55 Sea Lane Gardens Ferring BN12 5EG - Application to discharge condition 4 (landscaping) and 9 (Construction Management Plan) in relation to planning application FG/94/18/PL.

APPLICATION NO: FG/11/19/DOC

Description of Works: Application to discharge condition 4 (landscaping) and 9 (Construction Management Plan) in relation to planning application FG/94/18/PL.

55 Sea Lane gardens CMP

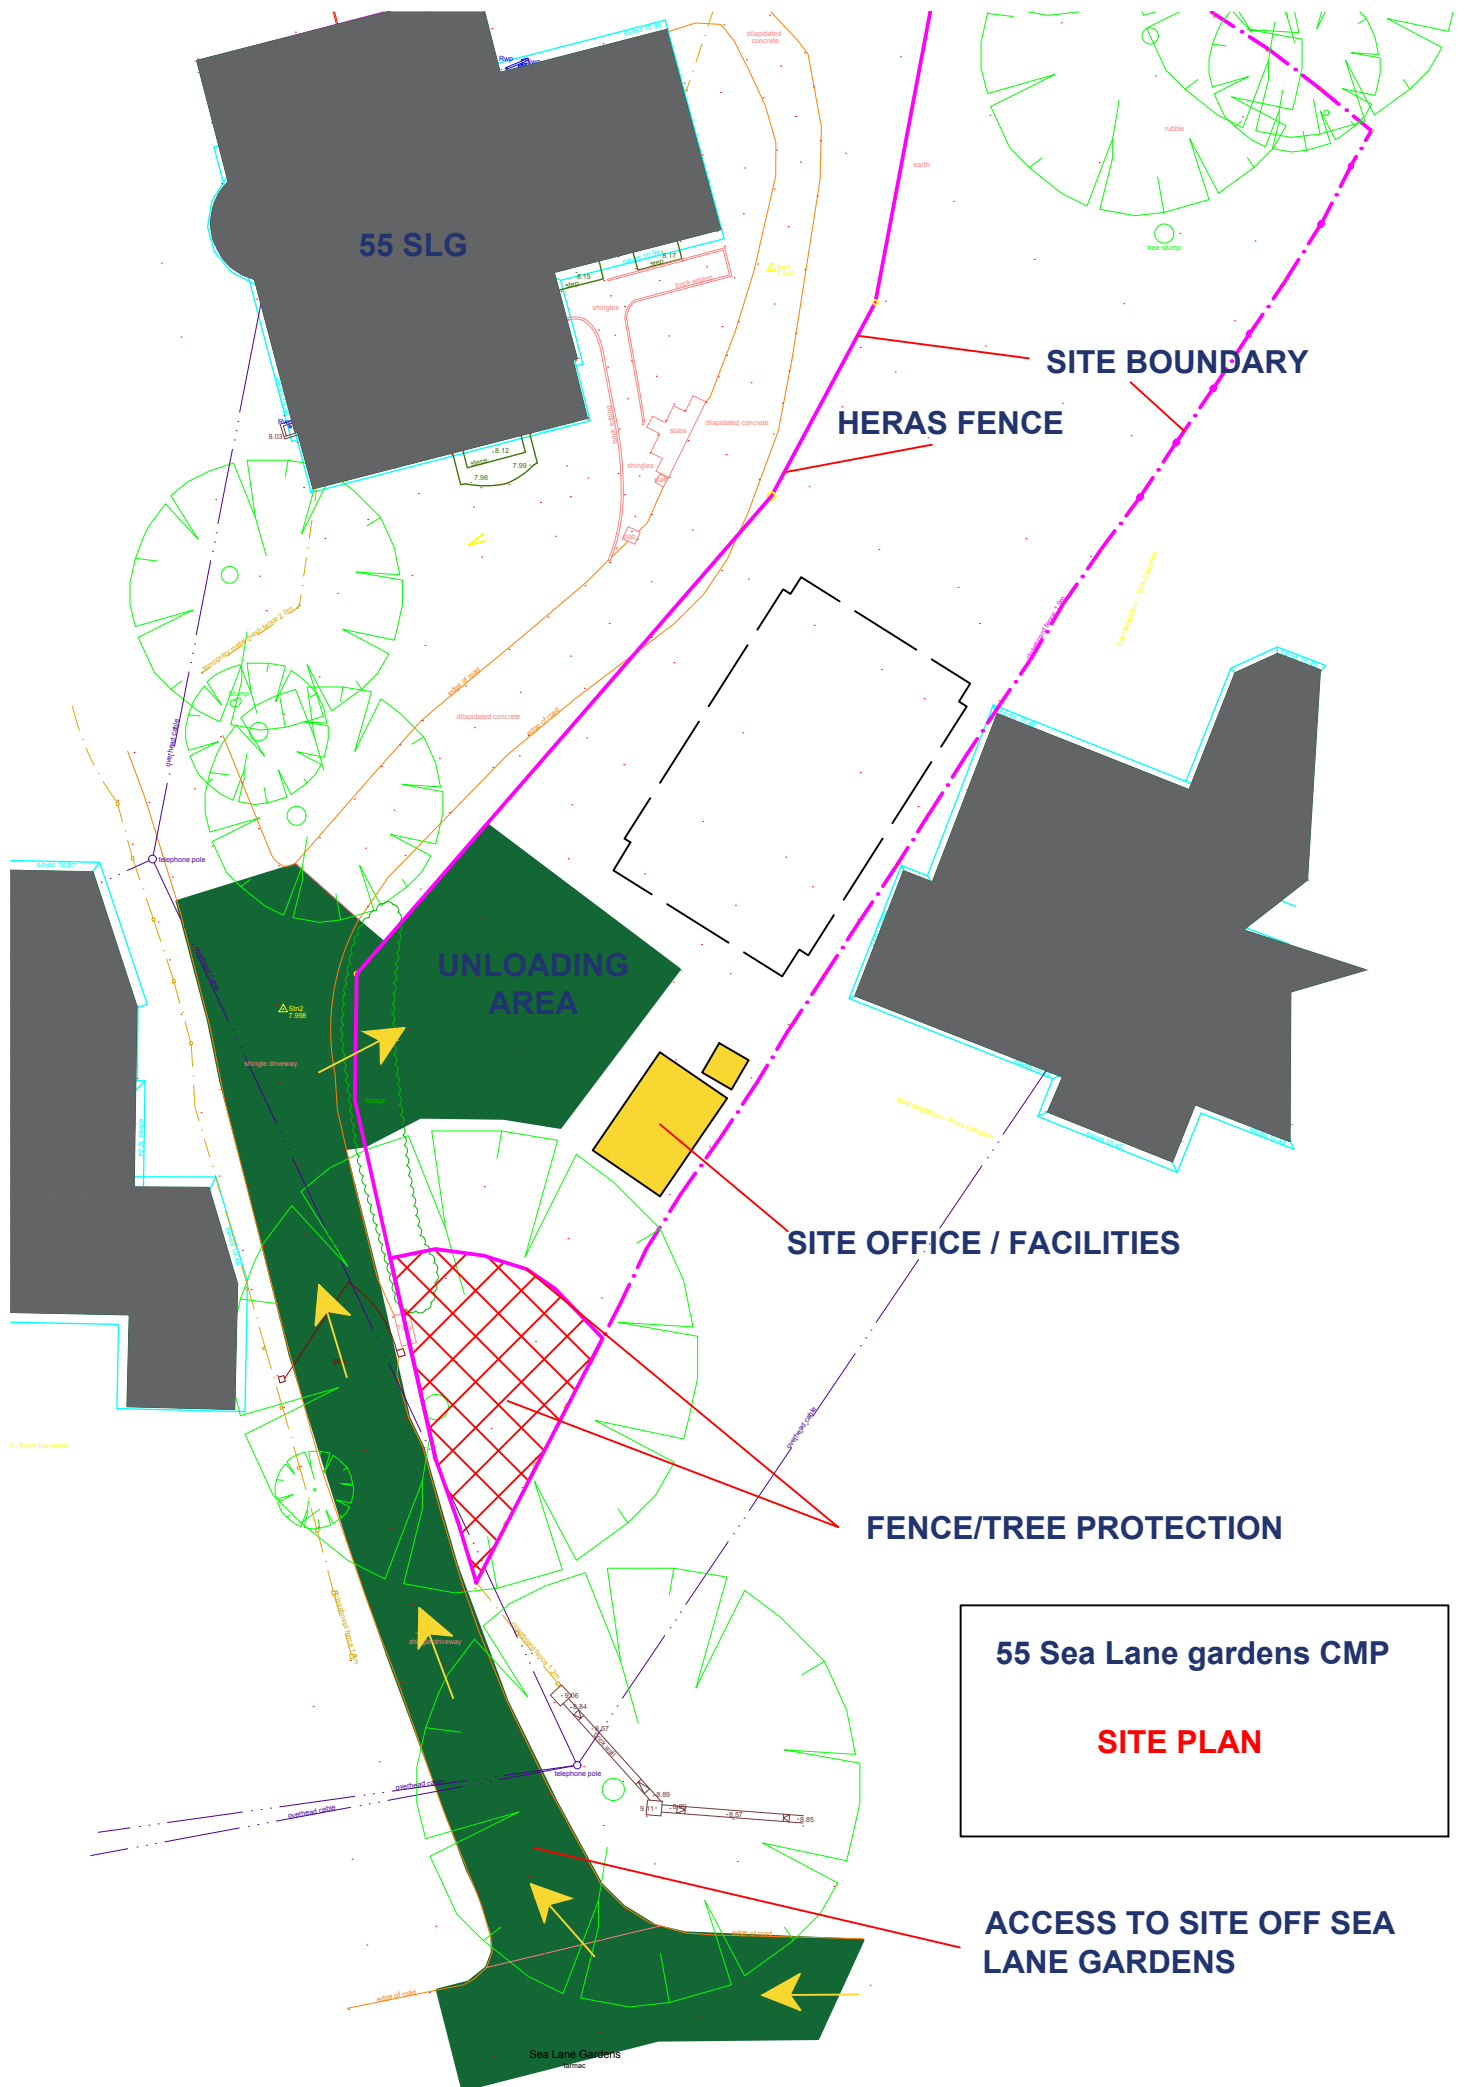
Thank you for consulting EH with regard to this discharge of conditions application. I have looked at the construction management plan submitted but note that there is very little detail contained within it.

My main concern is the lack of information relating to the construction hours on the site. I would expect these to be limited to the following:

- **No working on the site except between the hours of 08.00 – 18.00 Monday to Friday, 08.00 – 13.00 Saturdays and no working at all on Sundays or Bank Holidays.**

If the applicant was to add this additional information regarding the proposed working hours I would be happy to recommend the discharge of this condition.
